KITTTAS COUNTY COMMUNITY DEVELOPMENT SERVICES

December 29, 2020

Subject: Forest Ridge Phase 1 (LPF-20-00005) Final Long Plat – Return of Application and Request for Additional Information

LP-08-00014

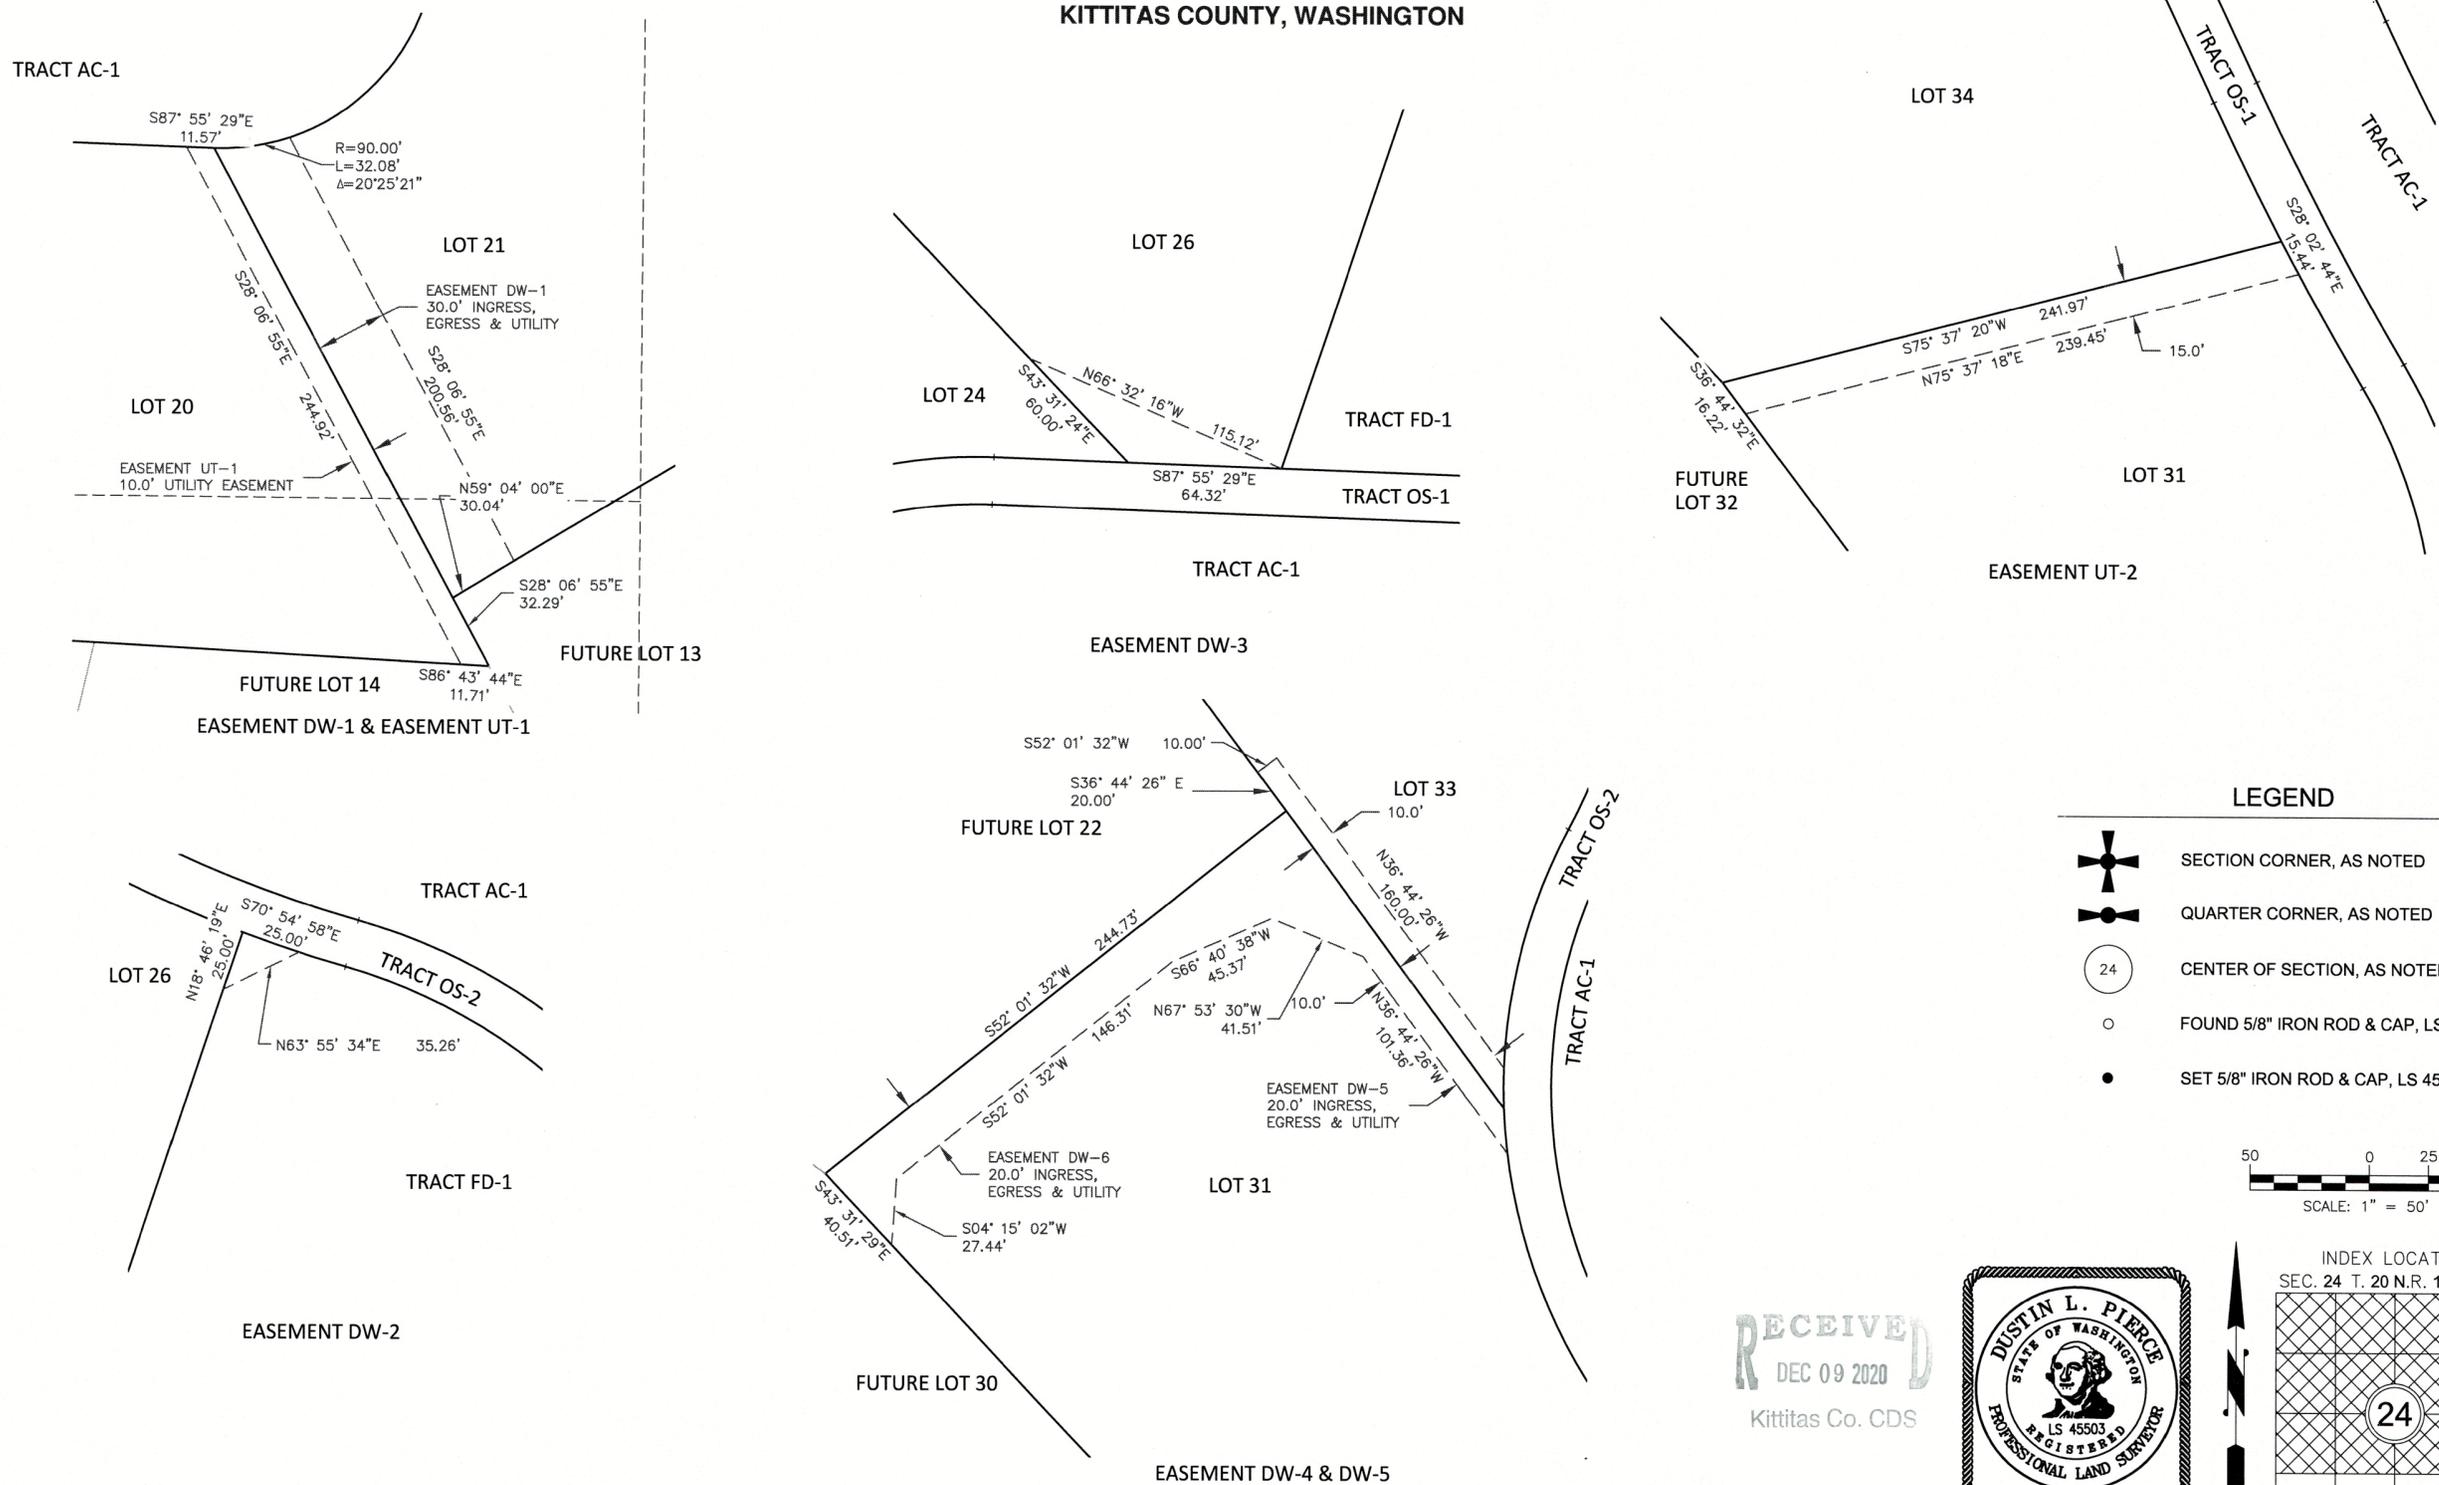
- Wetlands "A" and "B" as depicted on the attached wetland inventory map are not noted on the preliminary survey. Condition #11 of Resolution 2010-137 requires, "All wetland areas and their buffers shall be shown on the face of the final plat."
